MP 10_0048 MOD 4 Demolition of Harbour Control Tower

My response to this proposal will concentrate on the noise section of the Noise and Vibration Report.

Figure 4.1: Construction Traffic Routes

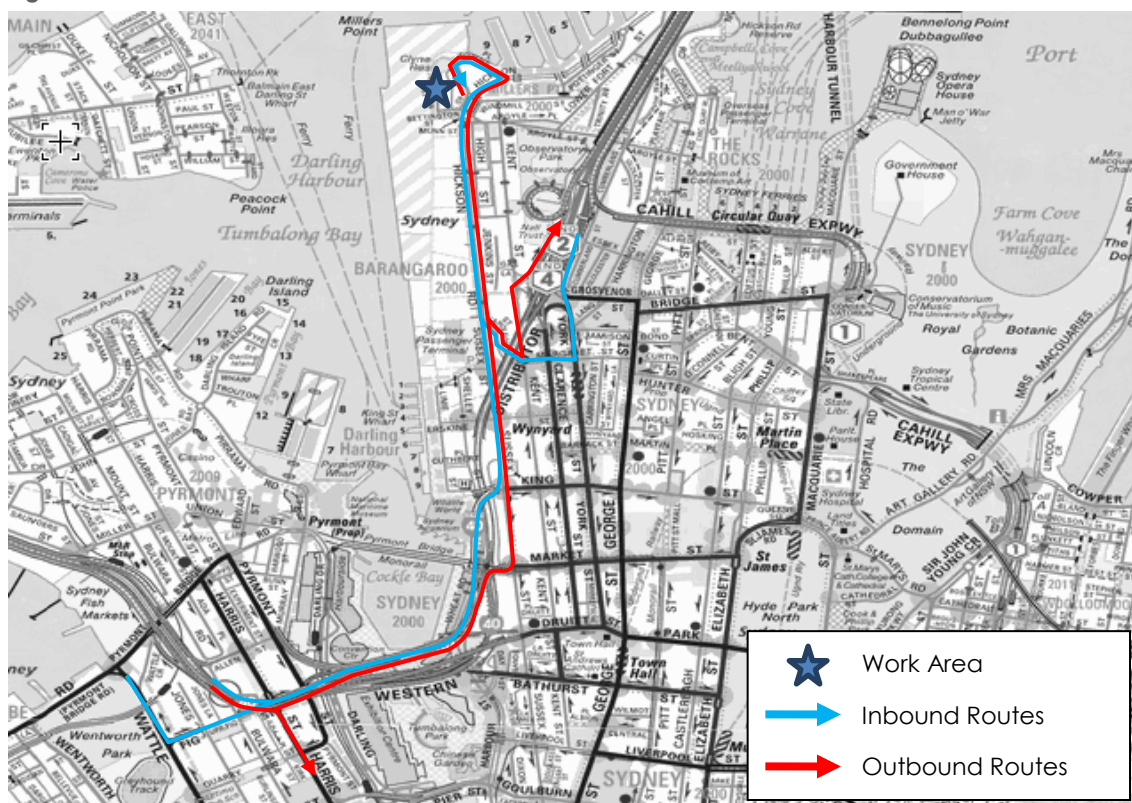
-In 4.2 and another place further on in the document the consultants state that "These (trucks) would enter/ leave via Pottinger St and Hickson Rd. This is impossible Pottinger St is only accessible from Hickson Rd and is blocked by bollards at the Windmill St end. The entry and departure route is Merriman to Bettington to Dalgety Terrace to Towns Place then to Hickson Rd. This may just be sloppy proof reading or it may be built in to the assessment of the noise affects on the streets after Merriman listed above.
